City of Albuquerque Stormwater Construction Site Inspection Report

General Information					
ESC File No.	M15E023B	Project Name:	Avid Hotel		
NPDES Id. No.	NMR1006J0 & 6IR	Location:	1441 Woodward Rd. SE		
1/10/2025	Owner	Contractor			
Operator	1441 Sunport, LLC		HEI Construction, LLC		
Contact name & title	Yogash Kumar & R-Nicholas Eveleigh				
e-mail	heiconstruction@yahoo.com & rne@hmsgallup.com		yogash@hmsgallup.com		
Contact Phone #	505-879-7168		505-879-7613		
COA Inspector	Chancellor English		Start/End Time:	12:30pm	
Construction Phase:	Graded, infrastructure				
Type of Inspection:	Regular	Storm Event	Past Storm Event >0.25"	311/Complaint	Follow Up
Weather at time of inspection?		clear		Temperature: ~	35
Estimated date of last storm 0.25" or greater		11/7/2024

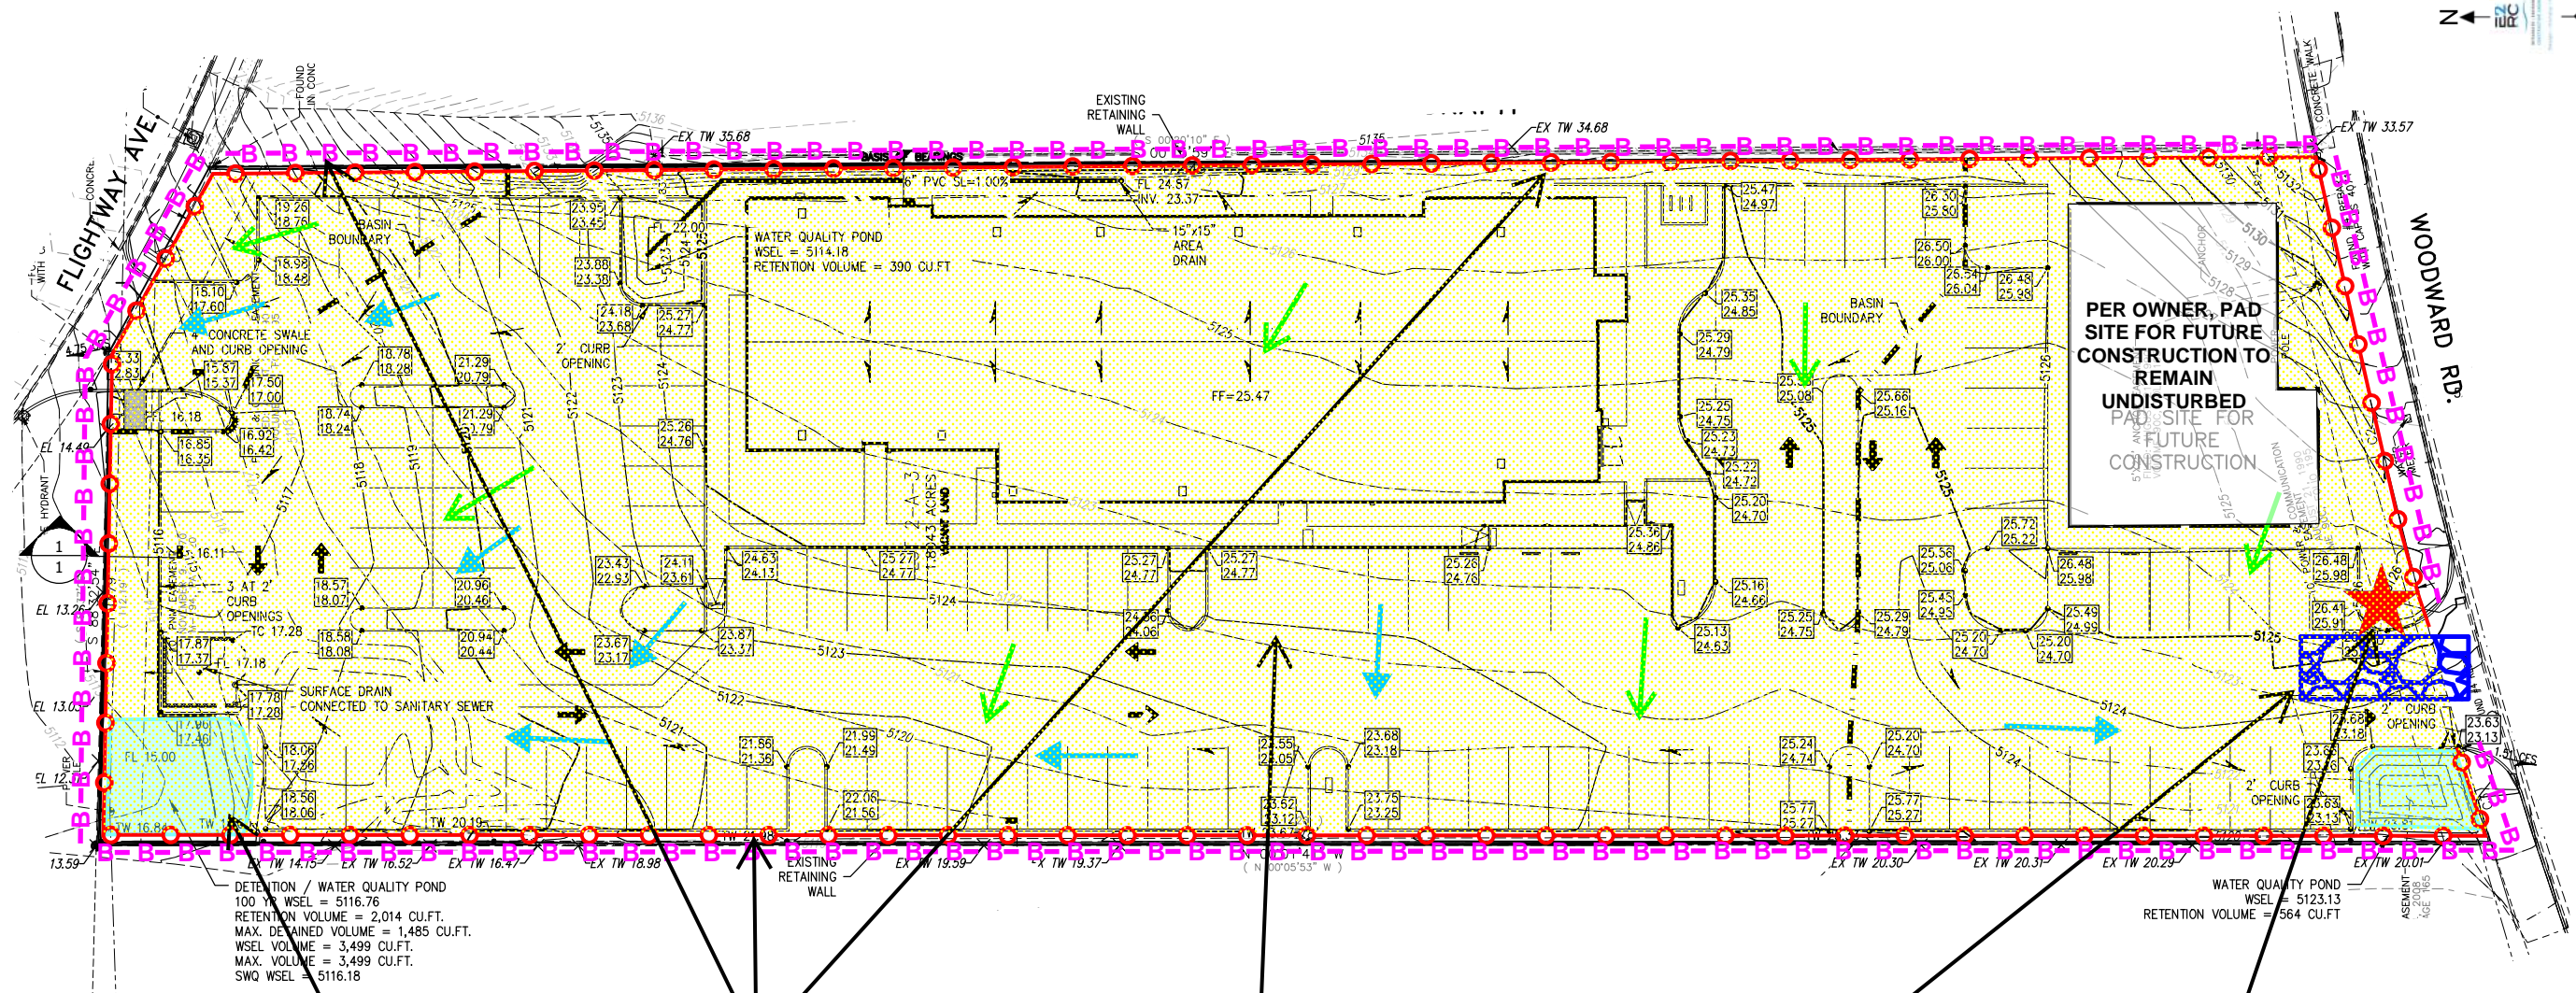
3	BMPs - The silt fence at the northwest corner and along the western border with Comfort Suites is at capacity and needs maintenance/repair, and the construction exit is full of sediment along with a dirt ramp in the curb in violation of CGP Parts 2.1.4 and 2.2.4. Required mitigation: Ensure all stormwater controls are maintained and remain in effective operating condition during permit coverage and are protected from activities that would reduce their effectiveness per CGP Part 2.1.4. Use appropriate stabilization techniques at all points that exit onto paved roads such as aggregate stone or turf mats per CGP Part 2.2.4.				
4	Washout - There is concrete washout on bare ground in violation of CGP Part 2.3.4. Required mitigation: Direct wash water into a leak-proof container or a leak-proof and line pit designed so no overflows can occur due to inadequate sizing or precipitation per CGP Part 2.3.4. Do not allow liquid wastes to be disposed of through infiltration or to otherwise be disposed of on the ground. Remove and dispose of hardened concrete waste consistent with your handling of other construction wastes in CGP Part 2.3.3.e.
